Our ref: MP 09 0155 MOD 6

**Tomingley Gold Mine (MP09_0155) MOD 6
Review of Modification Report**

Dams Safety NSW has reviewed the Modification Report for the proposed modification for Tomingley Gold Mine (MP09_0155) MOD 6 and has the following comments.

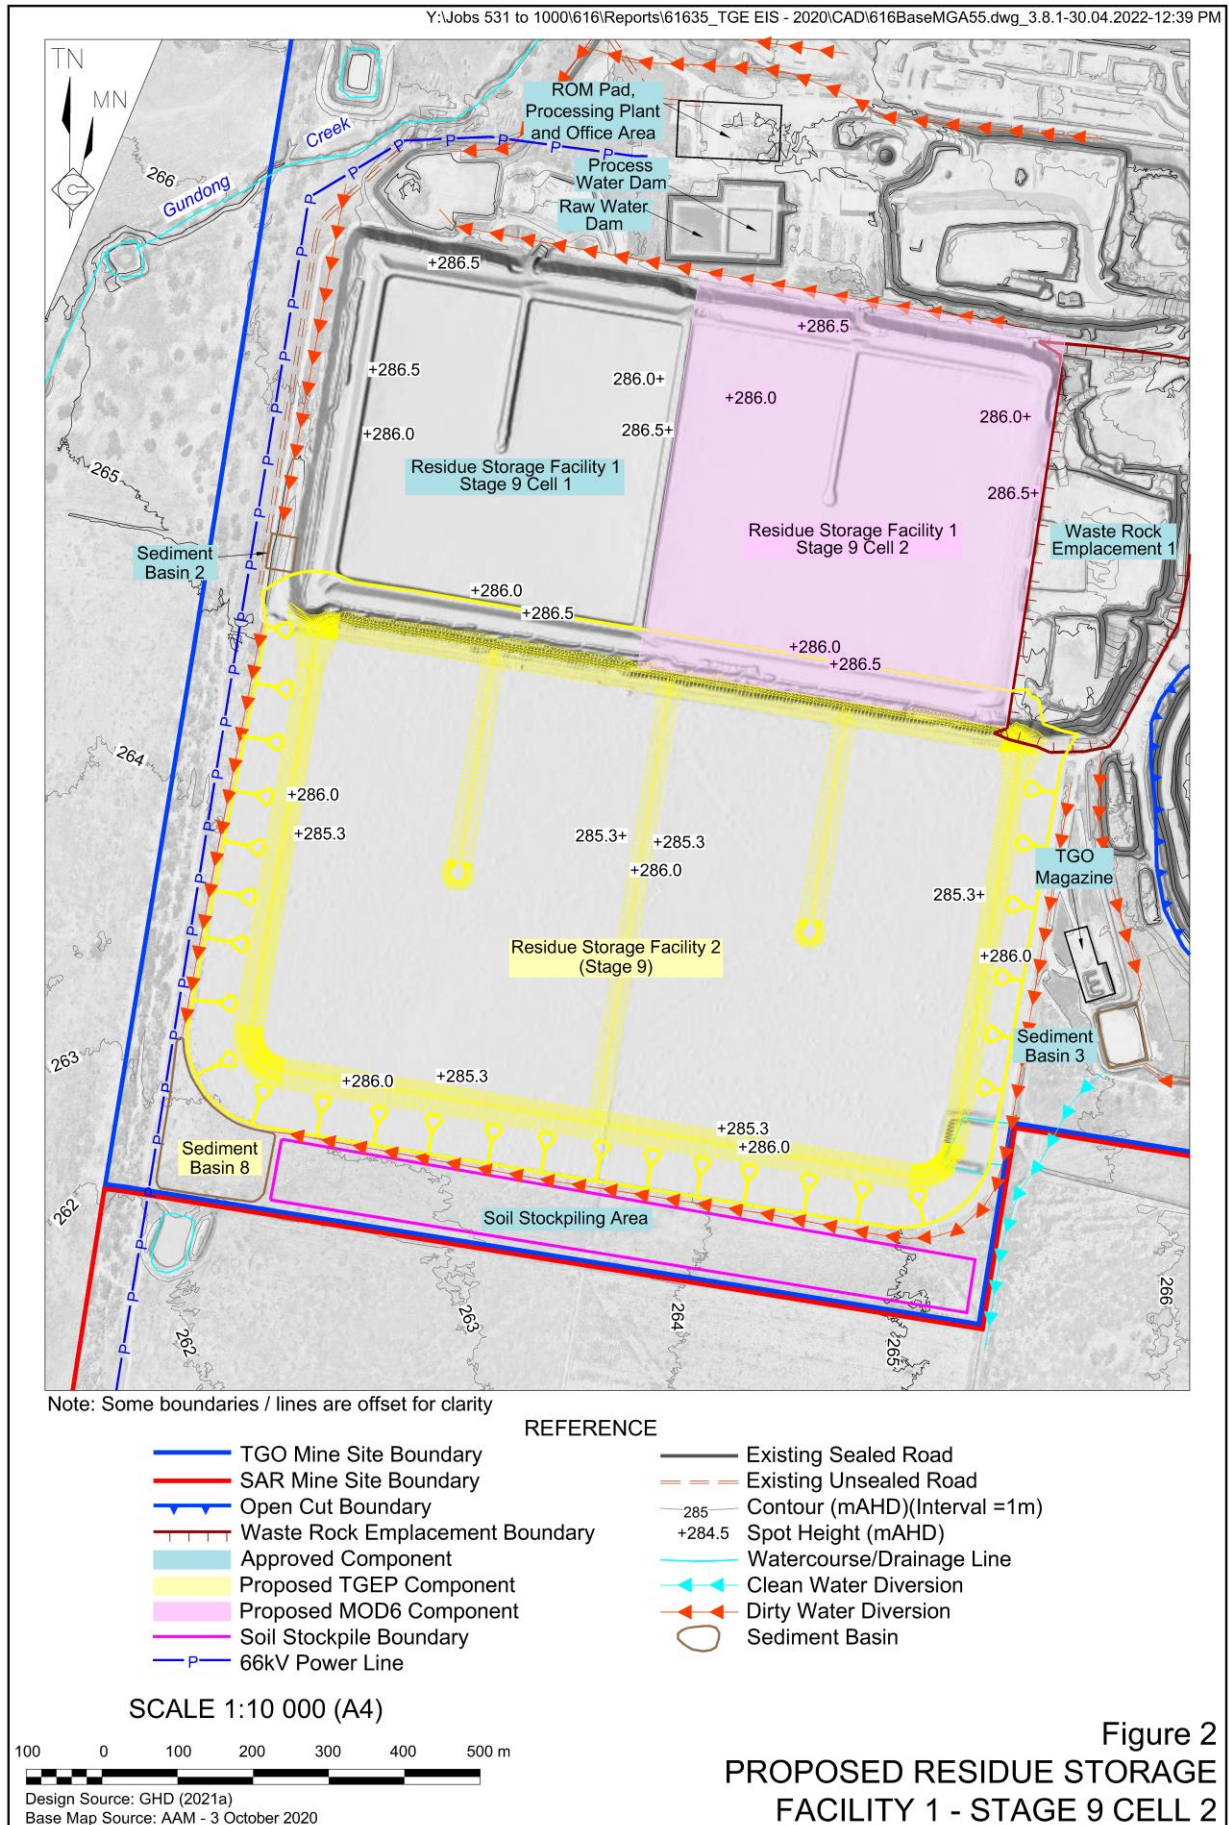
The Modification proposes an increase in proposed height for Cell 2 of Residue Storage Facility 1 at Tomingley Gold Mine. The existing RSF1 has been assigned a consequence category of 'Significant' largely due to the toxicity of the impounded tailings which contain cyanide in addition to toxic heavy metals such as arsenic and it is not anticipated that the proposed changes to Cell 2 will alter this.

Residue Storage Facility 1 is a declared dam and as such all modifications to the dam require preparation of design reports and construction by 'competent persons' as defined under Clause 3(1) of Dams Safety Regulation 2019. Because the dam is close to blasting activity it should be designed with this in mind. The current blasting limit that DSNSW has placed on the embankments of RSF1 is a ppv of 50mm/s.
